Department of Primary Industries

**Residential Subdivision, Lot 1 DP 1097743, Pacific Highway, Moonee Beach,
Coffs Harbour Local Government Area (SSD 7198, formerly MP 09_0067)
Comment on the Response to Submissions Report**

DPI has reviewed the Response to Submissions document and provides the following recommendations and advice:

Figure 12 Buffer landscape plan

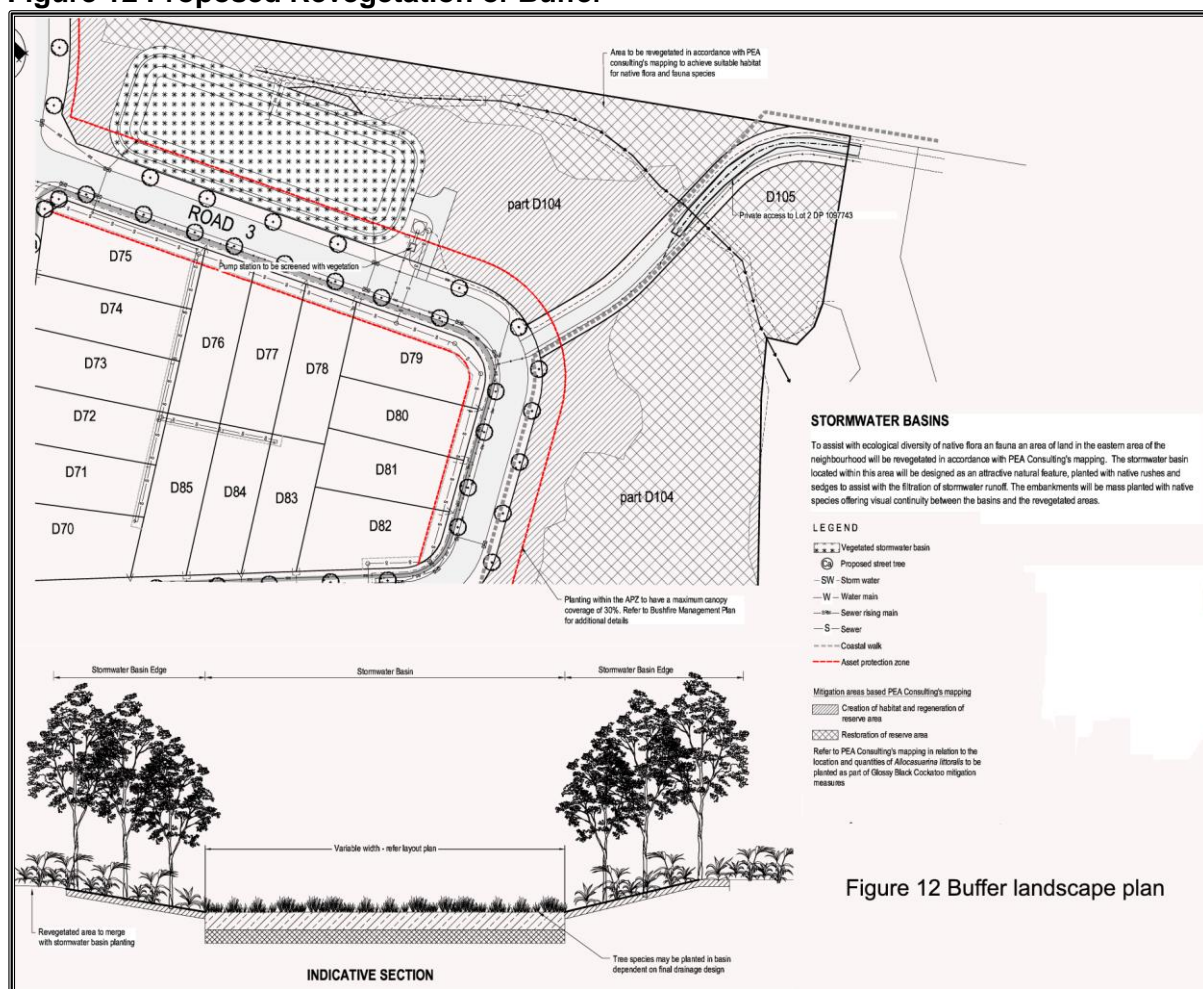
DPI Fisheries' submission dated 21 August 2013 reflects these policies and notes that the proposed buffer zone which varies between 64 – 85 metres, generally achieves a 70 metre width. Cognisant that immediately beyond the buffer the site incorporates areas of open space such as the coastal pathway and a development ring road DPI Fisheries could accept a buffer zone of this width. Importantly though DPI Fisheries' letter did also note that: *"At a minimum the buffer distances proposed for the development should be measured from the Highest Astronomical Tide Level"*

Measuring the proposed 64 – 85 metre buffer from the outer edge of the tidal zone, ie the Highest Astronomic Tide (HAT) is required to ensure the whole of the wetland is actually afforded protection by the buffer. The present proposal for a buffer that commences from the intertidal zone behind a stand of mangroves (Figure 1), approximating the Mean High Water Mark (MHW). The outcome is that the buffer intersects the intertidal wetland itself. Approximately half of all high tides will extend beyond the MHW. The edge of the estuary is generally considered to include up to the Highest Astronomic Tide. It is DPI Fisheries view that the HAT was the commencement point for the 100 metre buffers proposed in the Moonee Beach DCP and the Moonee Estuary Management Plan.

A further consequence of the present proposal is that areas of TYPE 1 (Highly Sensitive) Key Fish Habitat such as saltmarsh will not be fully protected by the buffer. In the subject proposal an area of intertidal habitat approximately >100m² occurs within the buffer itself rather than being surrounded and protected by it. It warrants noting that Figure 32 of the Concept Plan presents maps that concur with DPI Fisheries' assessment of the marine/estuarine habitats (*Surveyed extent of Marine Habitat in JW Planning Pty Ltd Part 3A Concept Plan Environmental Assessment – Pacific Highway Moonee (MP09_0067) June 2013 Page 59 of 120*) in contrast to the buffer edge proposed in the subject proposal. I have included a scanned image of the JW Planning map as Figure 2.

The buffer in the subject proposal remains inconsistent with the Moonee Beach DCP and the Moonee Estuary Management Plan and DPI Fisheries policy and guidelines. It is DPI

Fisheries view that the Response To Submissions Report has not provided a sufficient robust case to substantially deviate from the recommendation in these documents to fulfil a 100 metre buffer and DPI Fisheries recommends that the buffer is modified. However, as stated above and in previous correspondence, DPI Fisheries could accept a buffer zone of 64 – 85 metre (generally 70m) buffer from the outer edge of the tidal zone, ie the Highest Astronomic Tide (HAT) cognisant that immediately landward of the buffer the site incorporates areas of open space such as the coastal pathway and a development ring road.

- A buffer of 50-100 metres should be provided as measured from the highest astronomical tide.
- It is important that the level of stormwater treatment during both construction and operation of the development is of a standard that does not compromise key fish habitats or the values of the Solitary Islands Marine Park.
